Response to Authority Comments
SSDA 9403, 1 and 2 Murray Rose Avenue
Sydney Olympic Park
For Austino Property Group
31st January 2019

Response to Authority Comments
SSDA 9403, 1 and 2 Murray Rose Avenue
Sydney Olympic Park, Report

ptc. have been engaged by Austino Property Group to prepare responses to the Traffic and Transport related comments issued by the approving authorities, in relation to the proposed residential development at 1 and 2 Murray Rose Avenue, Sydney Olympic Park (SSD 9403).

Title
10-GENERAL ARRANGEMENT PLANS
GENERAL ARRANGEMENT
PLANS - S2 LEVEL B3
Drawing Number
DA-10-4700
Revision
A

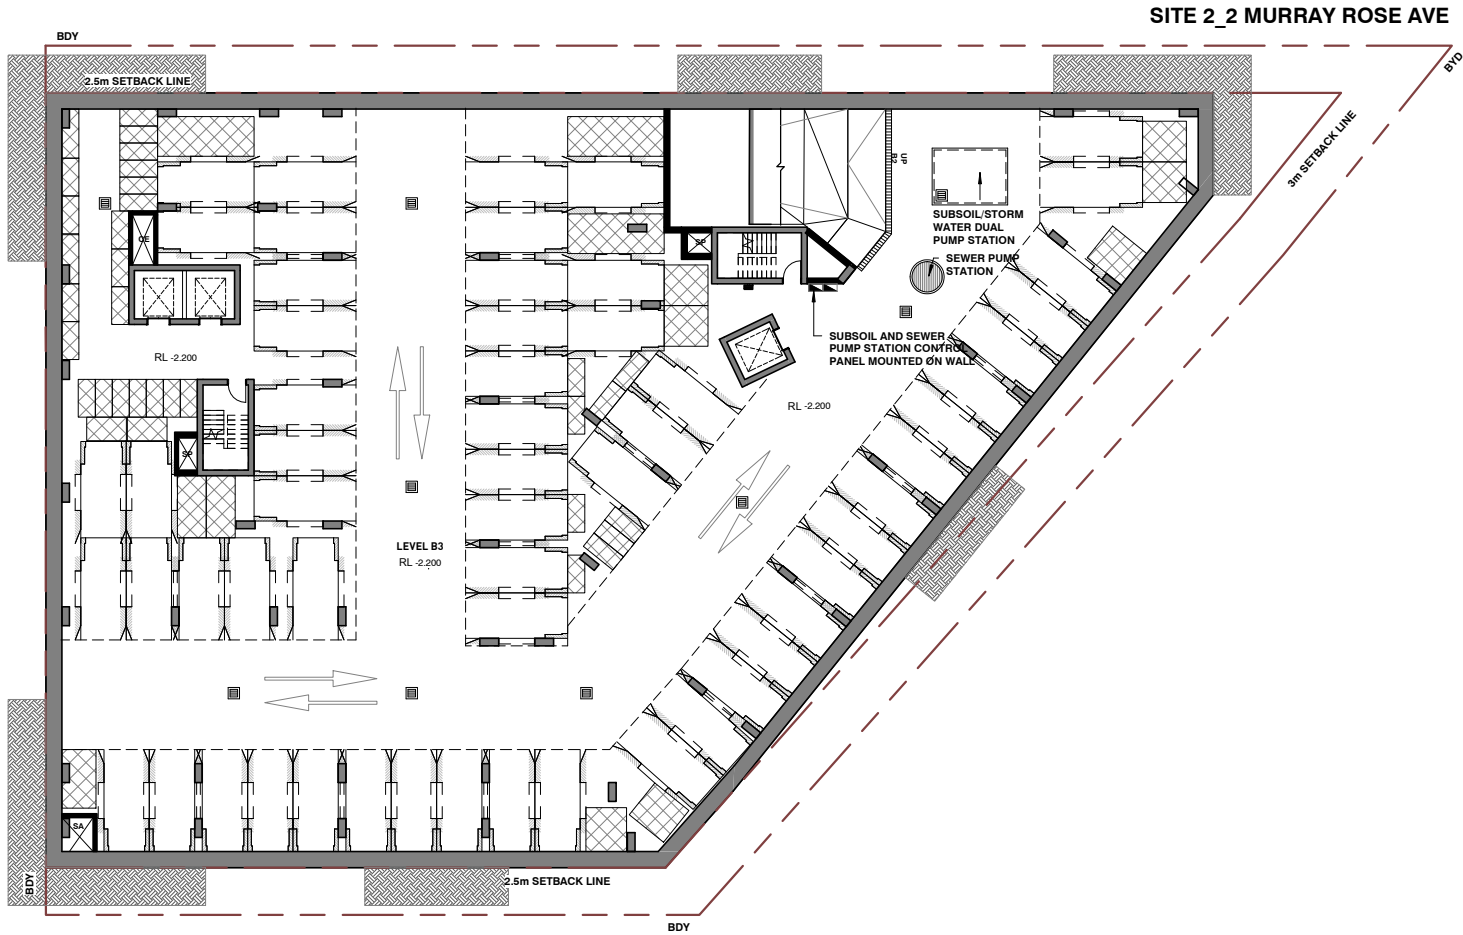
3.3.1 Comment - Accessible Visitor Parking

The application proposes no on-site parking spaces, In principle, SOPA supports minimising on-site parking in new developments.

However, Sydney Olympic Park maintains in ongoing legacy as a leading accessible and inclusive precinct and failure to provide accessible visitor parking spaces on-site is not supported.

It is unreasonable to expect mobility impaired visitors to use parking in public car park P6, given that the closest parking space is more than 150m from the primary entries to either residential building. P6 is also unavailable at certain times of the year for major event purposes, further restricting parking availability.

SOPA's Access Guidelines require a minimum of 2% of car parking to be provided as accessible spaces. Based on a maximum visitor parking rate of 42 spaces for 1 Murray Rose Avenue and 32 spaces for 2 Murray Rose Avenue, SOPA strongly recommends that at least one (1) accessible car parking space be provided on-site within each building

3.3.2 Response – Accessible Visitor Parking

Agreed. The design will be amended through the CC stage to accommodate at least one (1) accessible visitor space within the car parking provision for each site.
